SITE DEVELOPMENT PLAN
HOPE PHYSICAL THERAPY-PARKING LOT
THIRTEEN OUTLAWS, LLC
4850 AUSTIN BLUFFS PKWY
COLORADO SPRINGS, CO 80918

V2_Site Development Plan Comments.pdf Markup Summary

DETAIL GRADING

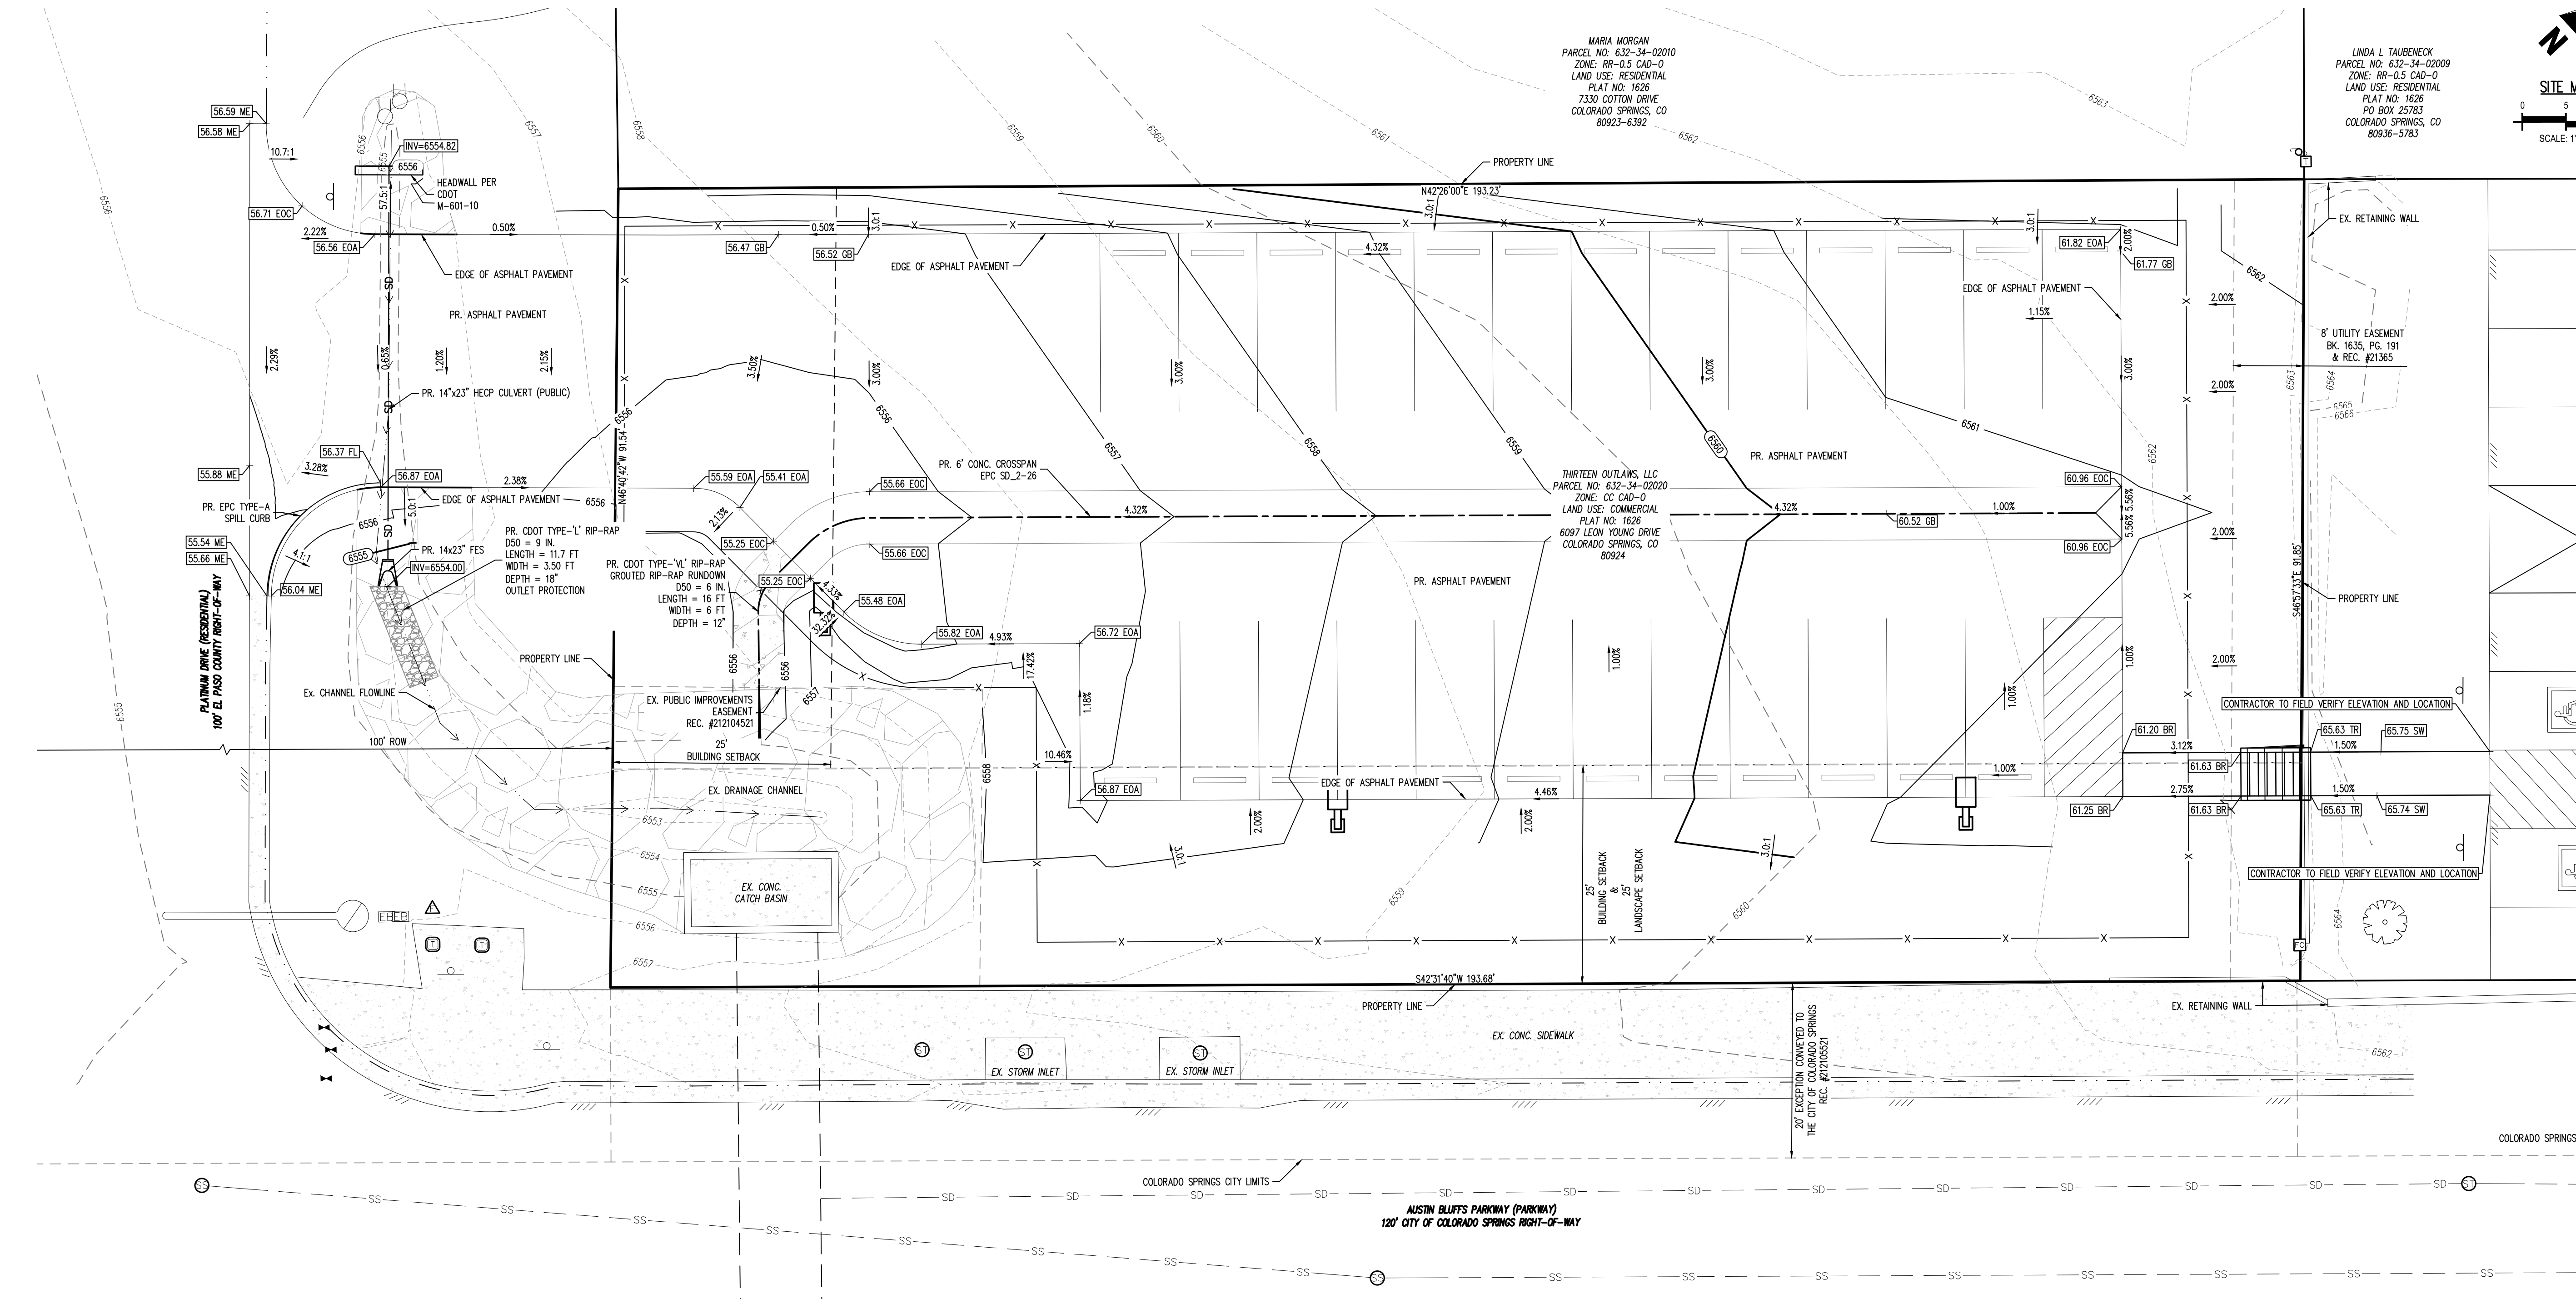
The drainage letter shows 11.7 feet length for the riprap. Please revise.

Show and label the riprap depth/thickness.

Drainage letter shows Type L rip-rap please coordinate with drainage engineer and revise.

Verify if proposed 18" storm line is accurate. Previous sheet shows a 14" x 23" HE RCP.

Delete label appears to not be pointing towards anything

Elevation note is cut off. Please revise

SITE DETAILS

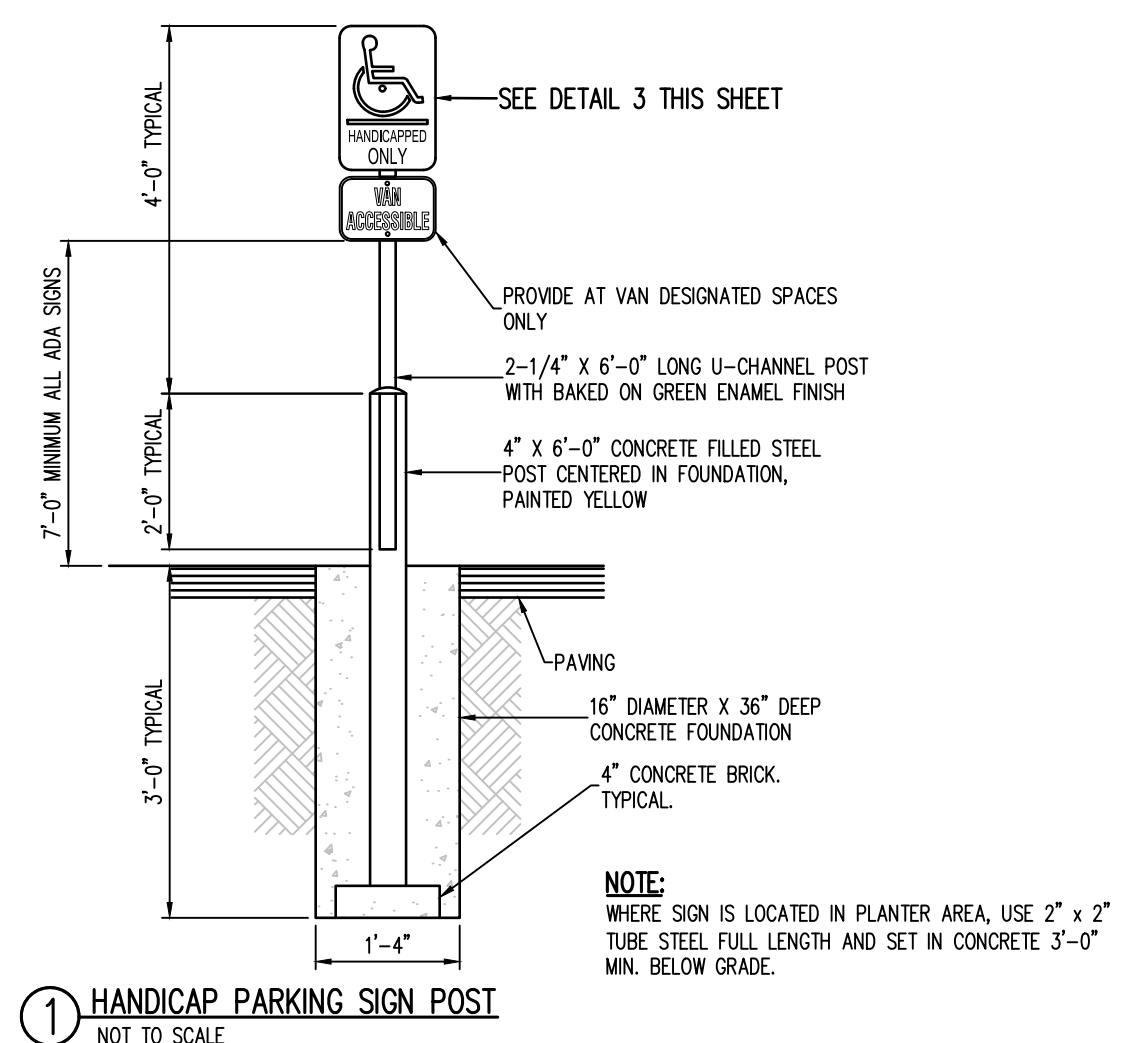
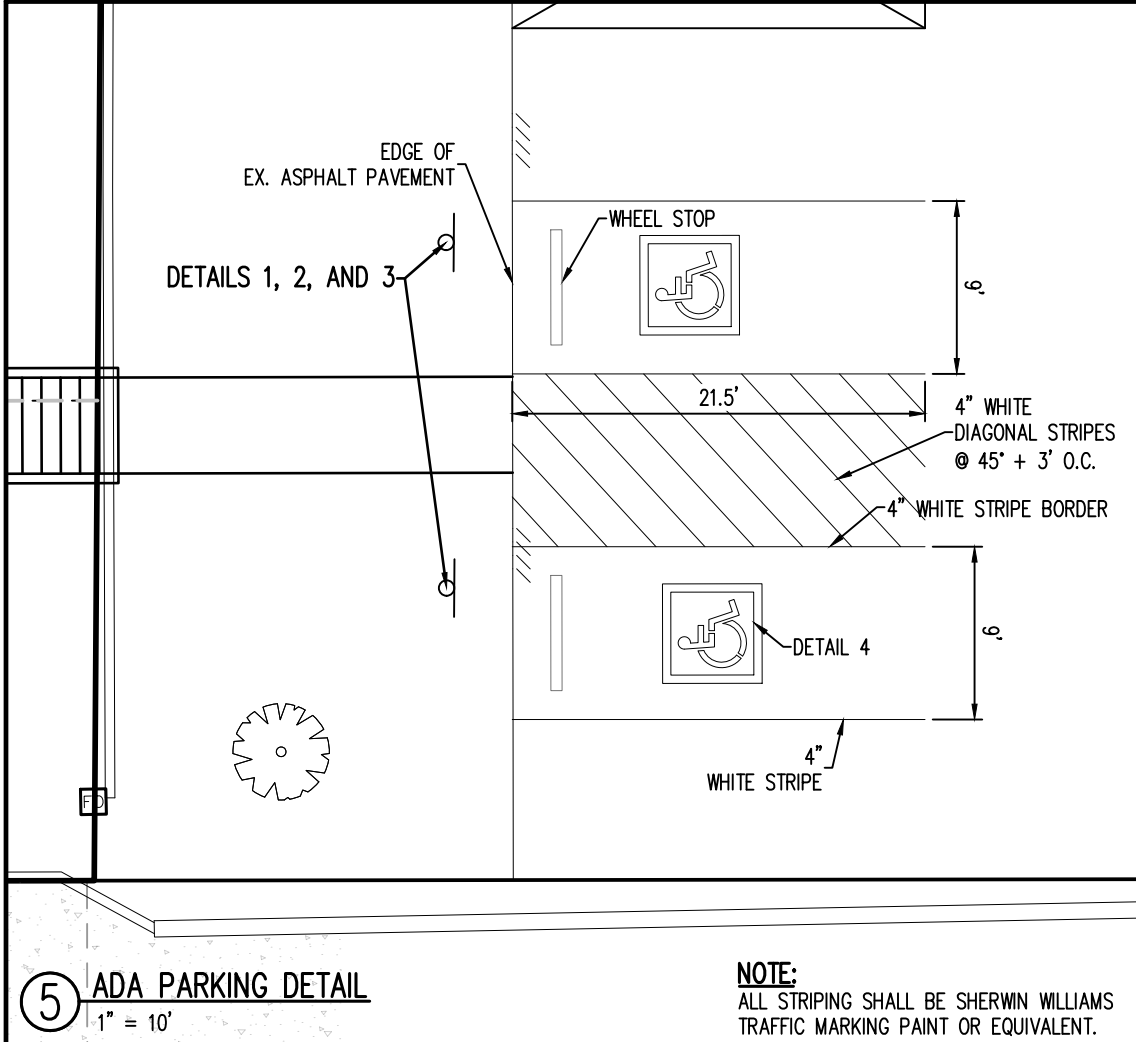
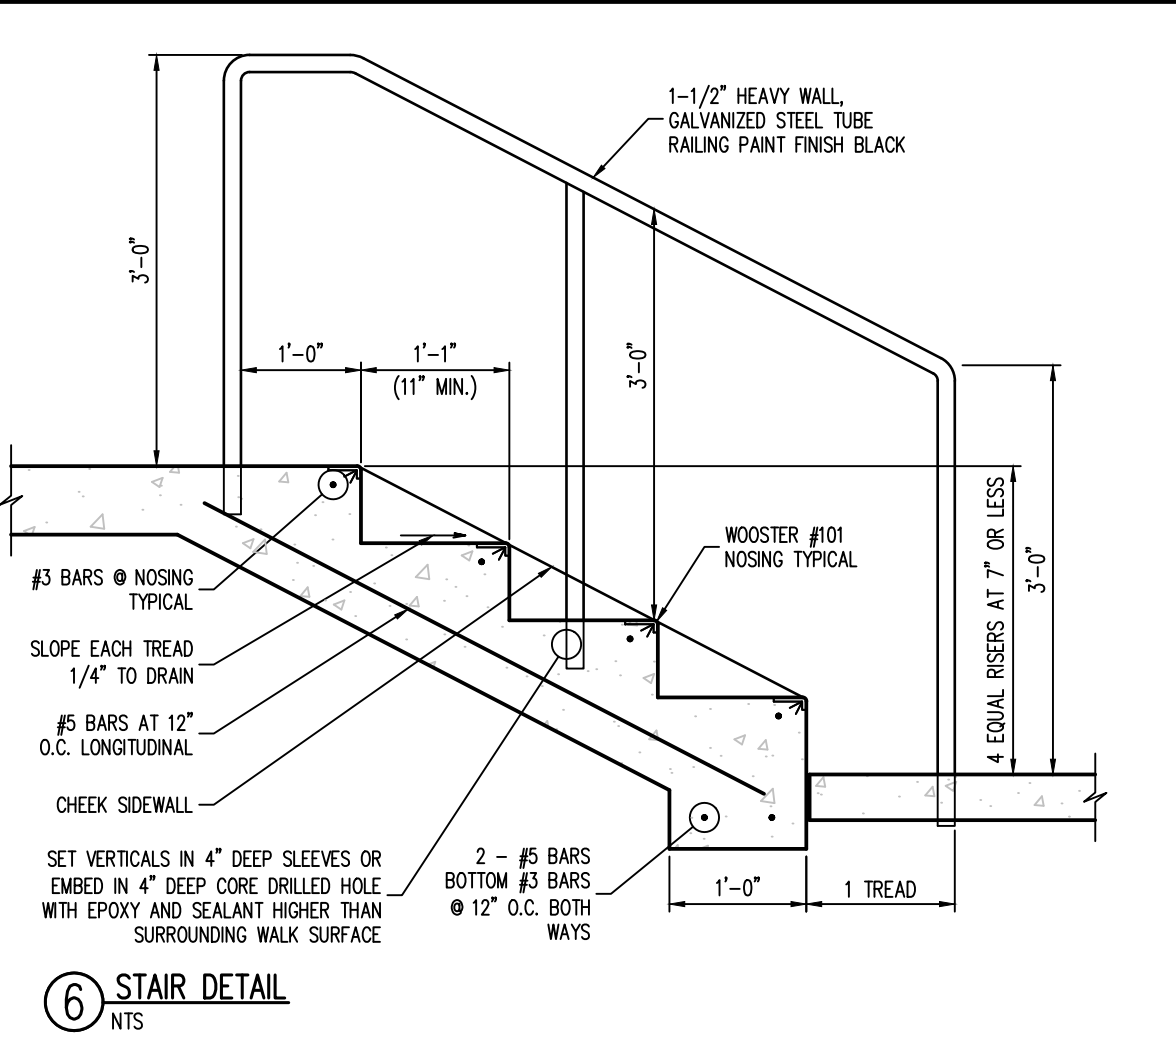
Where are these located? Did not see them shown or labeled on any of the plan sheets
